RE: 257 Goring Way, Ferring, West Sussex, BN12 5BY

Unfortunately this application is still invalid for the following reasons:

**257 GORING WAY, FERRING,
WEST SUSSEX, BN12 5BY**
 DRWG 257GW 005 PROPOSED
 ELEVATIONS / SECTIONS
 SCALE 1:100 @ A3
 PLANNING DRAWINGS
 15.02.2021
 (REV A - 23.02.2021)

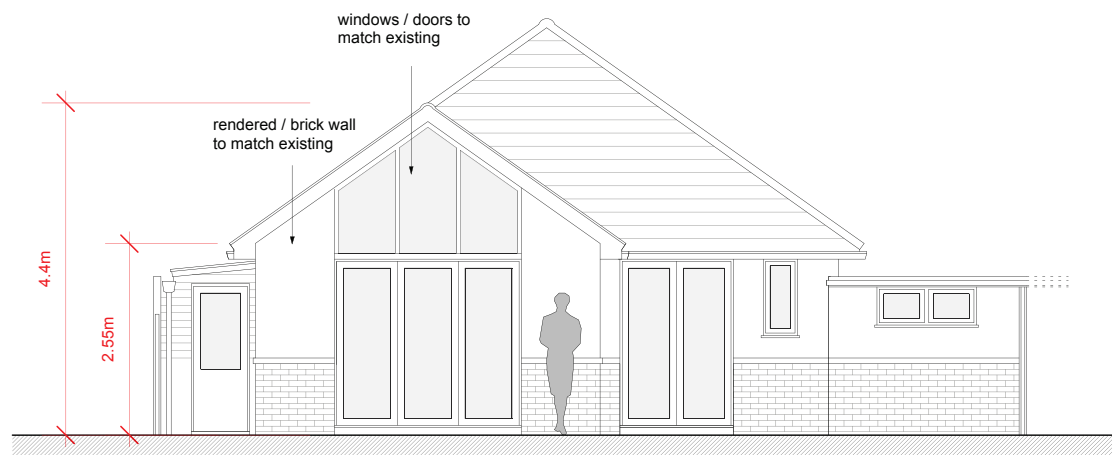
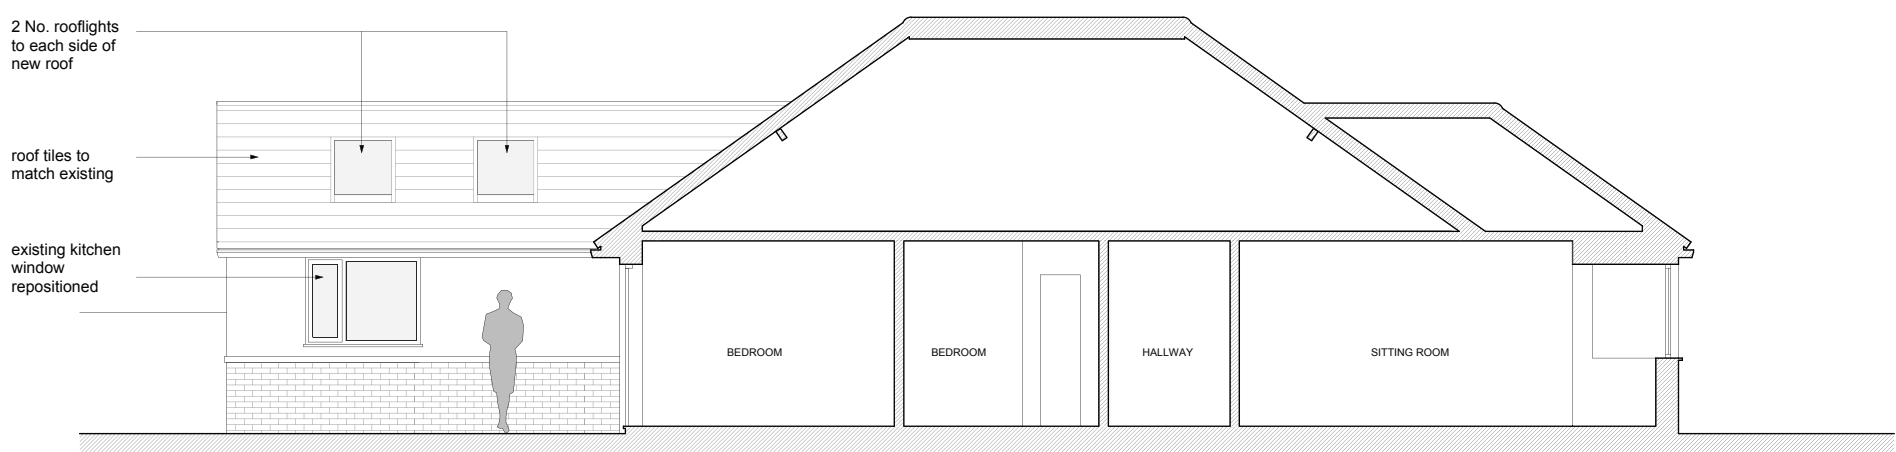
CIL Form: This appears to be blank. I have attached a copy, please fill in and return via email.
Location/Block Plans: These are missing a scale bar. Please review and amend accordingly.
Other side elevation required
